Rezoning Transportation Analysis

Petition Number: 2023-039

Date	Description
7-26-23	First Review (IW)
11-27-23	Second Review (DR)
2-21-24	Third Review (NK)

SECTION C - PUBLIC STREET (NETWORK)
2+ AVENUE, BUFFERED/SEPARATED BIKE LANES
SCALE: 1/4\"/>

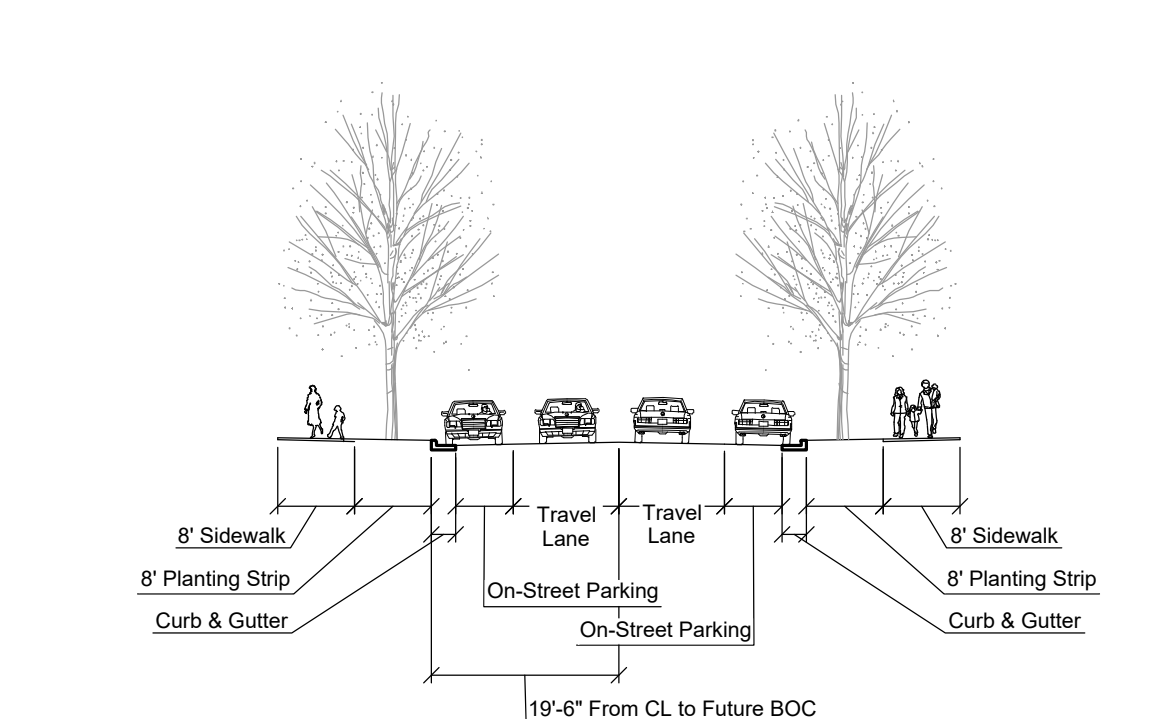
~~**Clarifying comment 11.27.23:** ROW dedication for Old Providence should be 43' based on the 8' sidewalk on Old Providence Road instead of the 6' sidewalk dimension shown on Section C.~~

~~New Comment 11.27.23:~~ Section C public street network sidewalk width does not match the conditional note. Revise Section C to have an 8' sidewalk like the conditional notes for the Old Providence Road section.
